From: Carol Reynolds
Sent: 05 May 2017 14:43
To: Planning.Responses
Subject: FW: Planning Consultation on: FG/41/17/PD

NOTIFICATION FROM ARUN DISTRICT COUNCIL
Town & Country Planning Act 1990 (as amended)
Town & Country Planning (General Permitted Development) Order 2015 Schedule 2
Prior Notification for a Commercial Permitted Development
APPLICATION **FG/41/17/PD**
NO:

Site Address: 2 Ocean Parade Eppingham Lane Epping BN12 5QQ

Description of Works: Application for prior approval under Part 3, Class M for change of use from retail (A1) to dwellinghouse(C3)

PROPOSED FLOOR PLAN

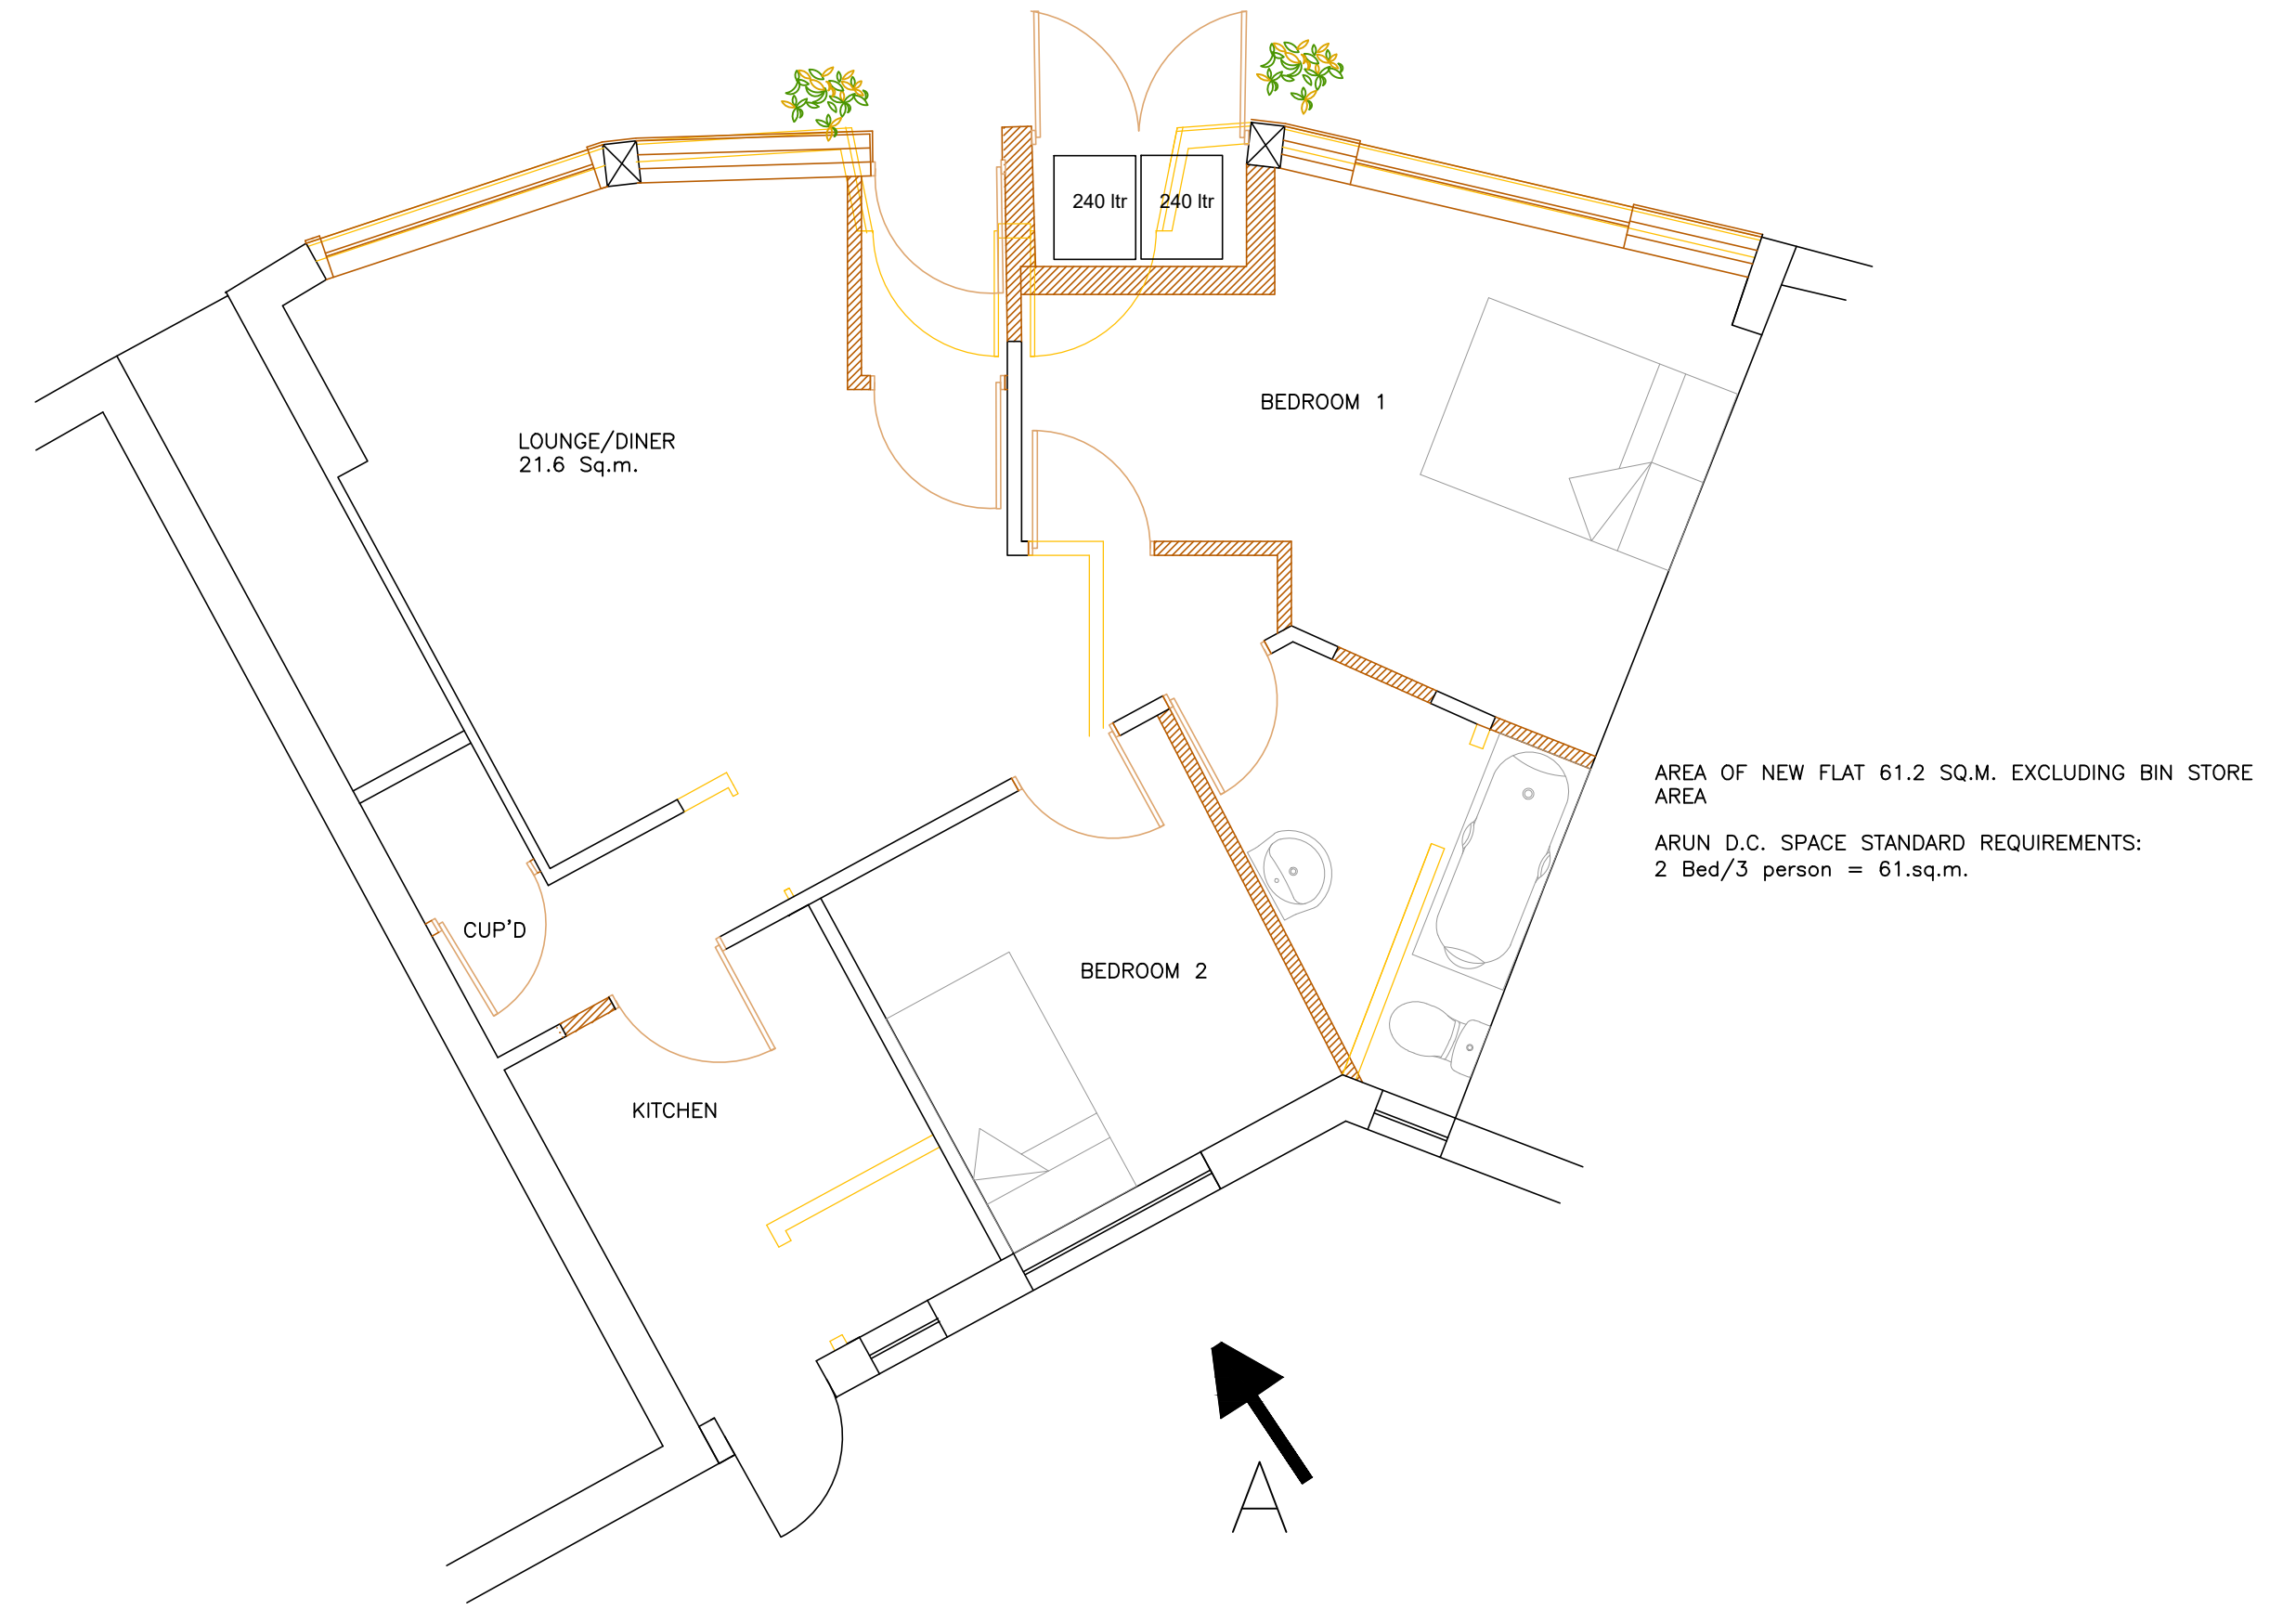
Environmental Health: Acoustic attenuation to be provided to all ceilings and walls so as to prevent excess noise transmission.
